Helios DCO

EN010140

Summary Note of Burn Gliding Club Submissions and Evidence

Environmental Statement Figure 7.20: Landscape Strategy Plan Sheet 1 of 3

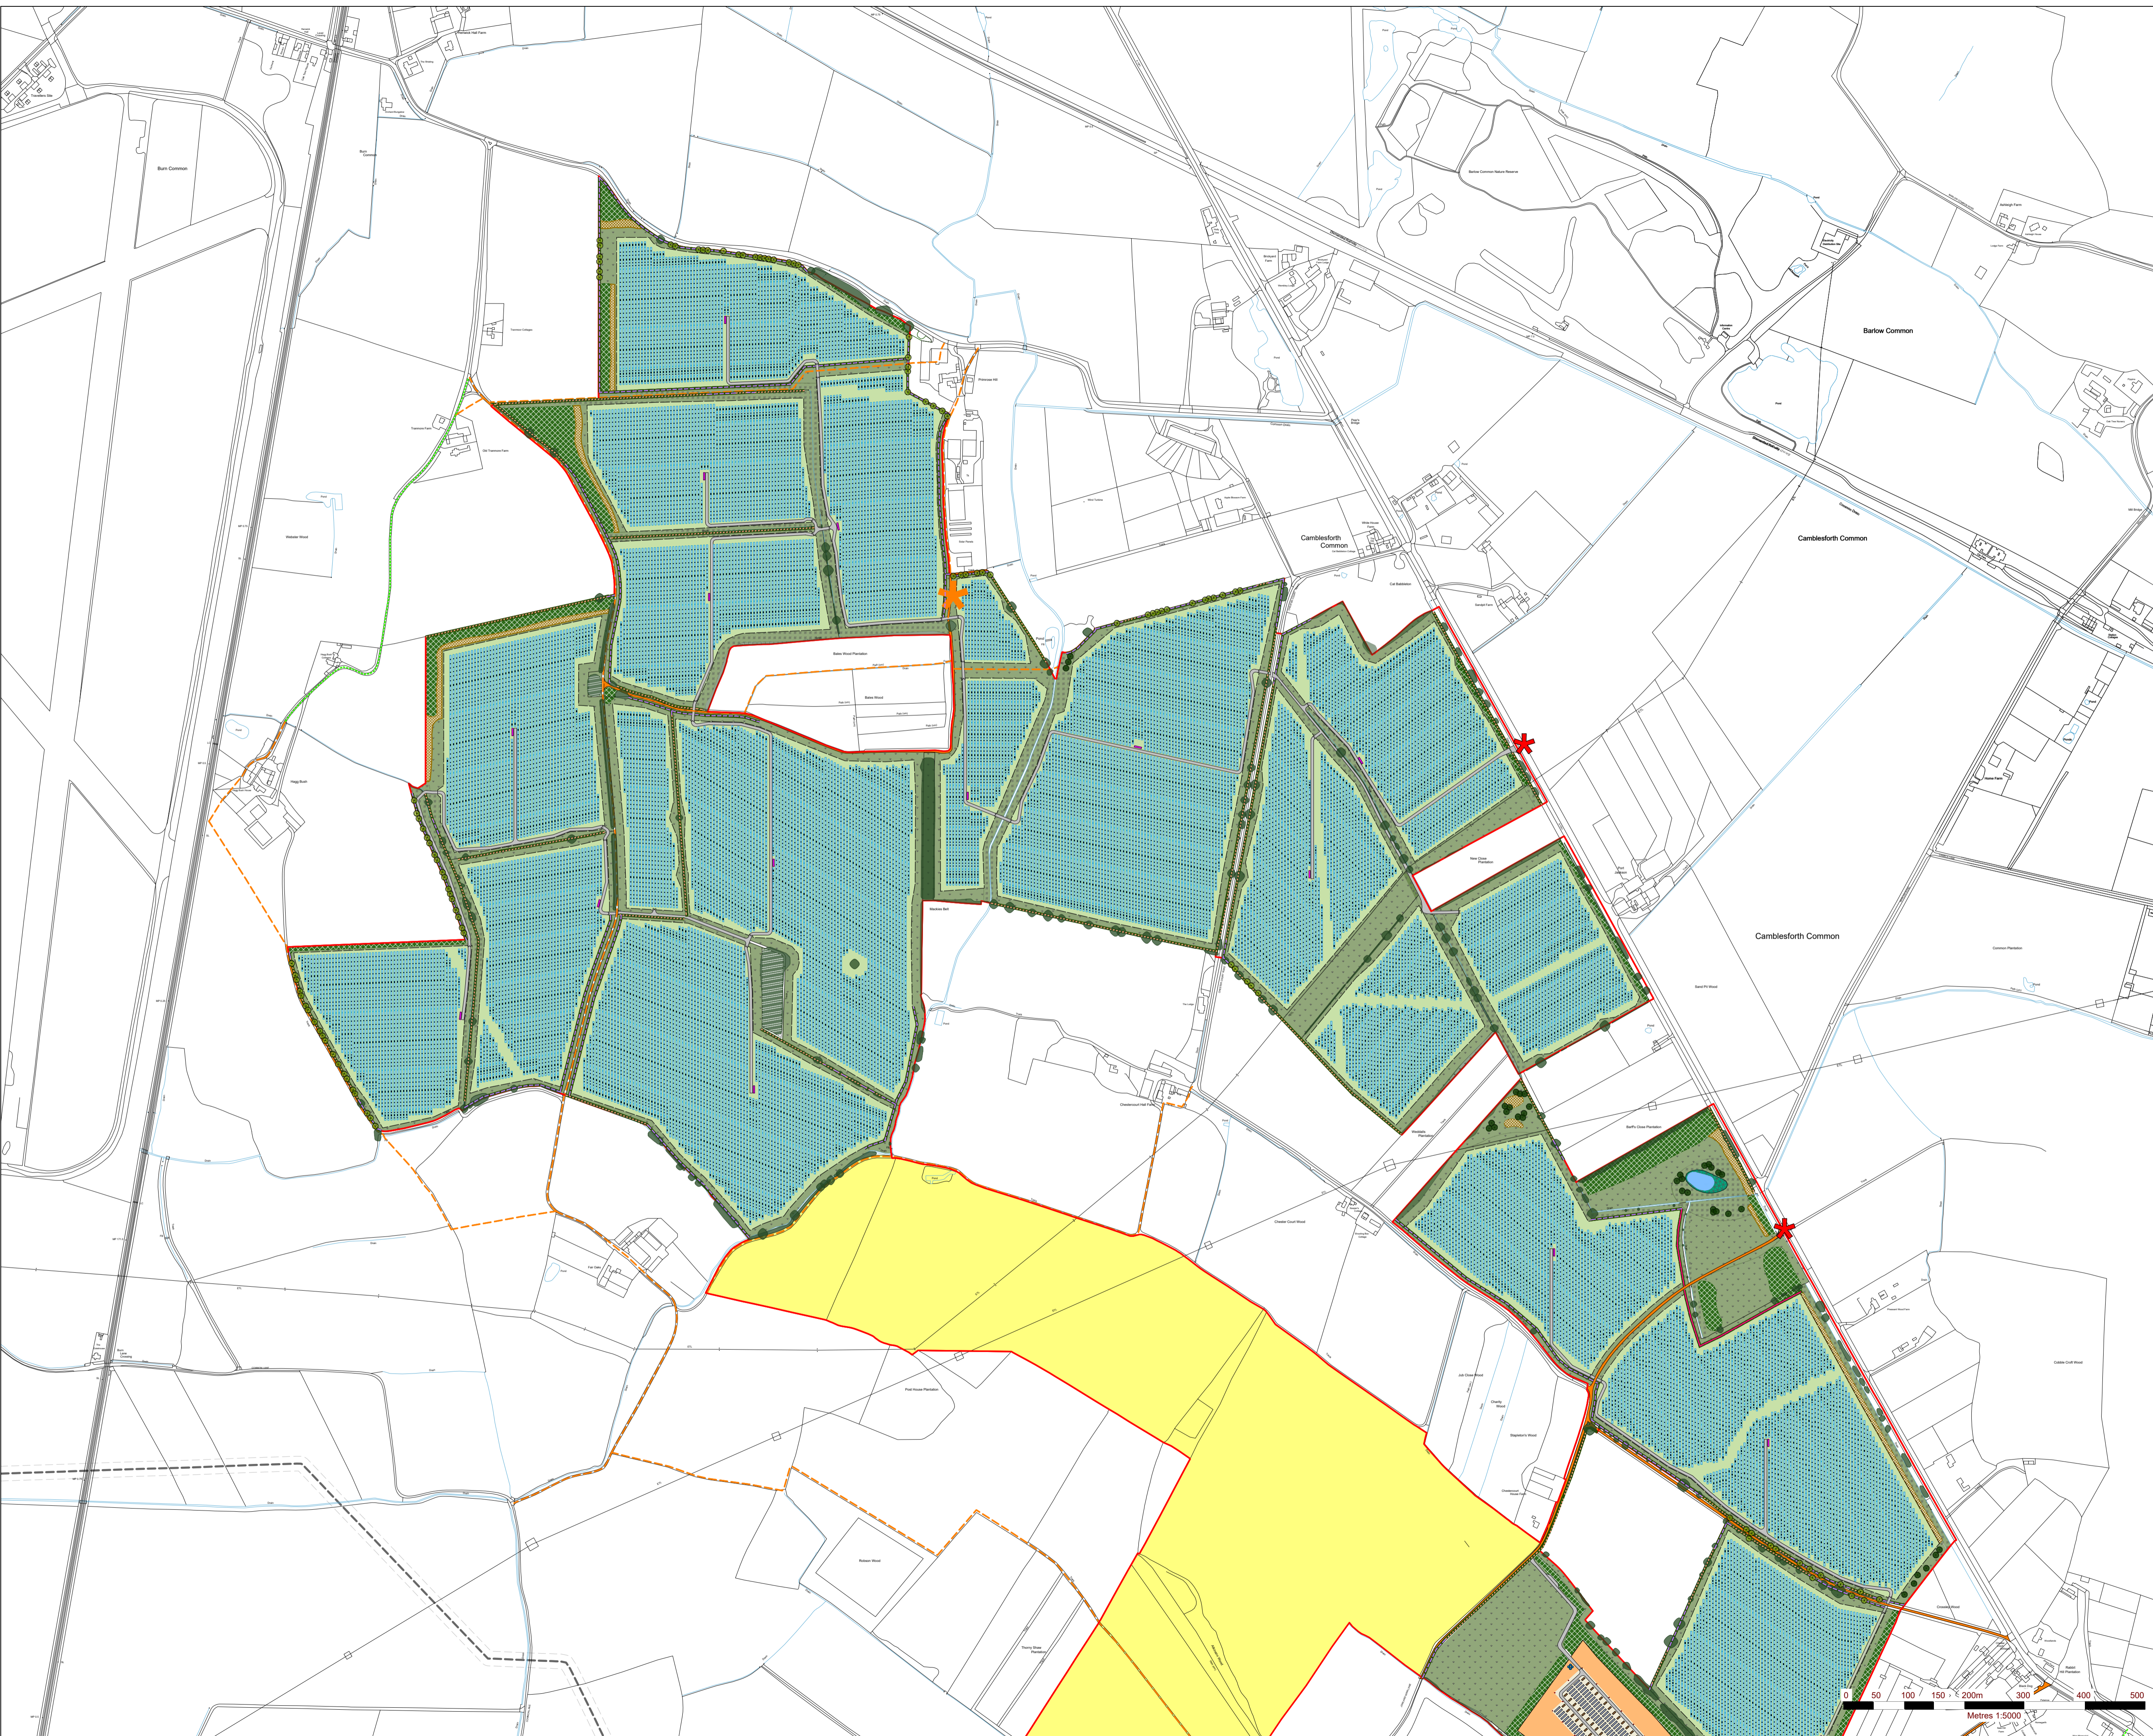
The enclosed plan (taken from the Applicant's documents and headed 'Burn Gliding Club Essential EFATO Mitigation Measures') identifies by number, all of the fields currently available should they be required for an engine failure on take off (EFATO) or an emergency landing. The field that might be chosen as the safest for landing is dependent on the state of the fields, crops and the status of the crop as well as the point at which an EFATO or emergency occurs determines which field is chosen as preferable.

The BGC is prepared to accept that Field 4 as shown on the plan is acceptable. In fields 3, 5 and 6, it is necessary for aviation safety reasons to omit some of the proposed solar panels as follows (and as shown on the plan):

Field 3 – This is the most suitable field for aircraft (fixed wing glider tow or winch launched glider) taking off from Runway 07. No solar panels should be erected within a minimum 100m wide swathe on the northern edge of the field, parallel to the C330 road as shown on the attached plan and highlighted with green dashes;

Fields 5 and 6 - These are the most suitable fields for aircraft (fixed wing glider tow or winch launched glider) taking off from Runway 15. The presence of HV and EHV cables in this area

already constitutes an aviation safety risk and the presence of the solar panels would compound to this. . No solar panels should be erected within a minimum 100m wide swathe along the south-western edges of these fields as shown on the attached plan and highlighted with green dashes.
